Our ref
PLAN-033709

Date
23/07/2020

Proposal: Demolition of Wings House & the erection of 81 No. replacement dwellings (80 net new dwellings), access arrangements, sustainable drainage measures, public open space, landscaping & all other associated works. This application is a Departure from the Development Plan.

Site: AL/46/20/PL: - Wings Nursery, Lidsey Road, Woodgate, PO20 3SU.

Drawing Status	INFORMATION		
Client	Southern Housing Group Ltd		
Project	Land at Wings Nursery Lidsey Road		
Drawing Title	Constraints Plan - Drainage and Flood Risk		
Scale	Date	Drawn By	Checked By
1:500	Jan. 2020	SPB	MJA
Drawing No.	Rev.		
D1757-PL101	-

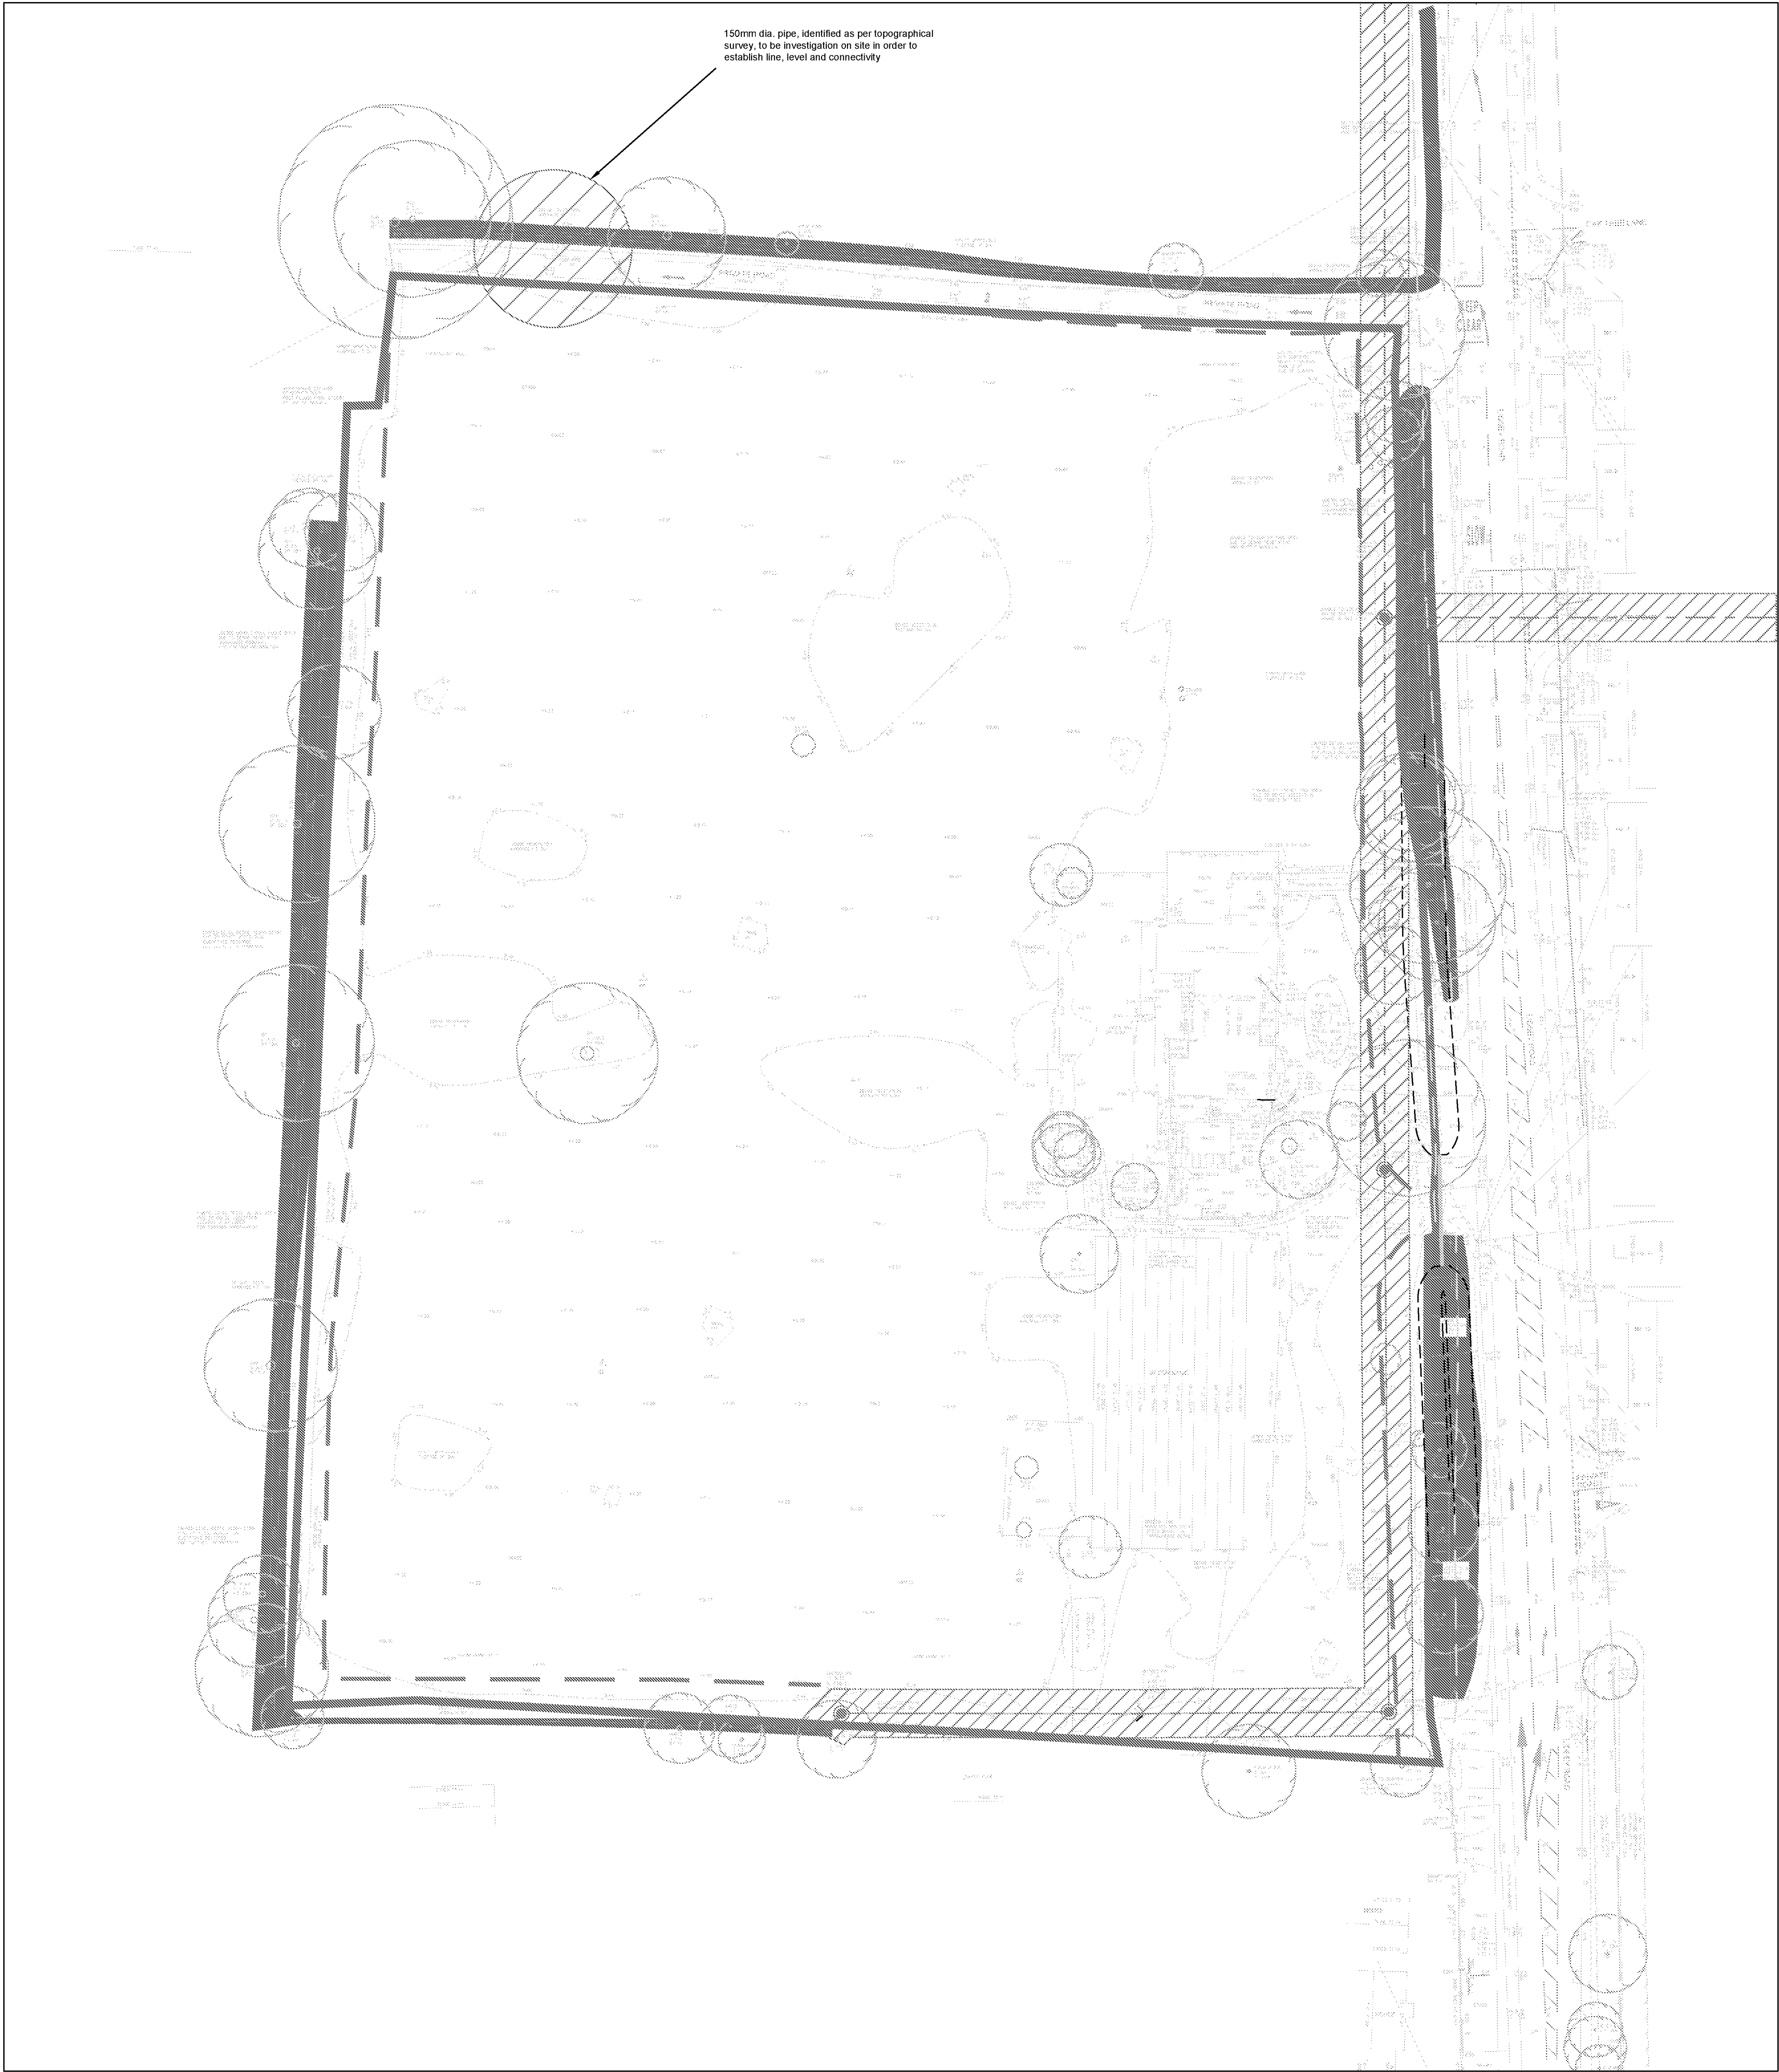
Please find attached a plan of the sewer records showing the approximate position of a public foul sewer within the site. The exact position of the public foul sewer must be determined on site by the applicant before the layout of the proposed development is finalised.

- The 150 mm public foul sewer requires a clearance of 3 meters on either side of the gravity sewers to protect it from construction works and to allow for future access for maintenance.

- No development or tree planting should be carried out within 3 meters of the external edge of the public gravity sewer without consent from Southern Water.

- No soakaway, swales, ponds, watercourses or any other surface water retaining or conveying features should be located within 5 meters of a public sewer.
